THE STAR
MODIFICATION 13
(MP 08_0098)

RESPONSE TO
SUBMISSIONS
(HERITAGE)

5 NOVEMBER 2018
PREPARED BY

1 PROPOSED SITE PLAN - ROOF_PV CELL LOCATION
1:500

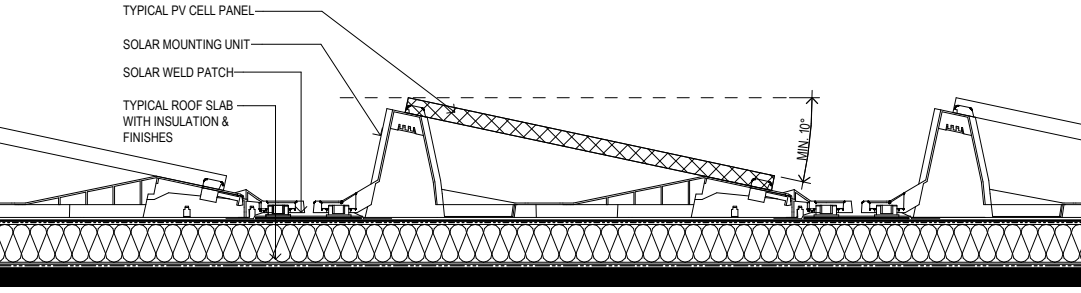
Drawing Mod13-AS1500 prepared by dwp has been reviewed by Urbis Heritage and the proposed location of photovoltaic cells would be installed in the following locations:

- ◆ The roof of the Darling Hotel;
- ◆ The roof of the Astral Hotel; and
- ◆ The roof of the Lyric Theatre.

As these elements would be located on the roof of contemporary buildings located at the site they would not be visible from the public domain and would have no physical impact on any fabric of heritage significance. The installation of the photovoltaic panels would be supported from a heritage perspective and would have an acceptable level of heritage impact.
